Subject: Response to submission – Water Management
Date: 28 March 2025

Arcadis provide the following letter in response to the pre-determination submissions from DCCEEW Water (Ref OUT24/12628), dated 20 August 2024. This response is an addendum to the previous submitted Kingswood Batter Energy Storage System – Appendix M Water Impact Assessment (SSD-63207219).

Figure 5-1 Indicative location of water management basin

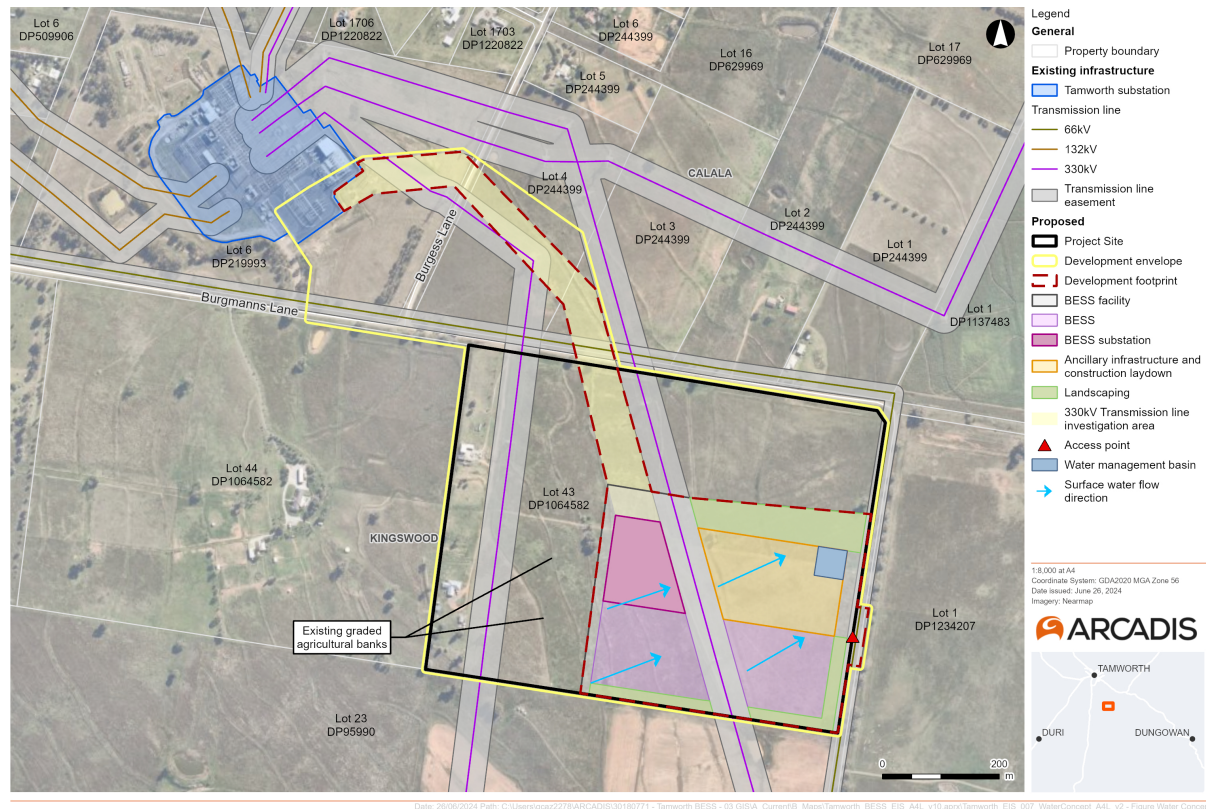
The proponent should review and determine the applicable water regulation instrument for the project's proposed water management basin, considering the following options:

- 1. Harvestable Rights,*
- 2. Exclusion under Schedule 1, Clause 3, of the Water Management (General) Regulation 2018,*
- 3. Water Access License.*

A water management basin is proposed for the project to retain stormwater for reuse on site. The proponent has not demonstrated how the basin fits within the water licensing regulatory framework. Dams which capture runoff and are designed to hold water need to be considered under Harvestable Rights, a relevant exclusion under Schedule 1 of the Water Management (General) Regulation 2018, or need to hold entitlement on a water access licence if the other two options are not applicable.

The WaterNSW Maximum Harvestable Rights Calculator was used to determine that up to 1.83 ML dam capacity can be provided on the Project Site (26.09 ha).

There are no existing dams on the site. The proposed water retention basin will be within the Maximum Harvestable Rights allocation.

A water balance was completed for the Project Site which demonstrated that a basin with a capacity consistent with the Maximum Harvestable Rights may meet construction period daily demands 88% of the time (depending on weather conditions). Refer to Attachment 4 for further details. This would likely need to be supplemented with another water supply to meet the daily demand during construction.
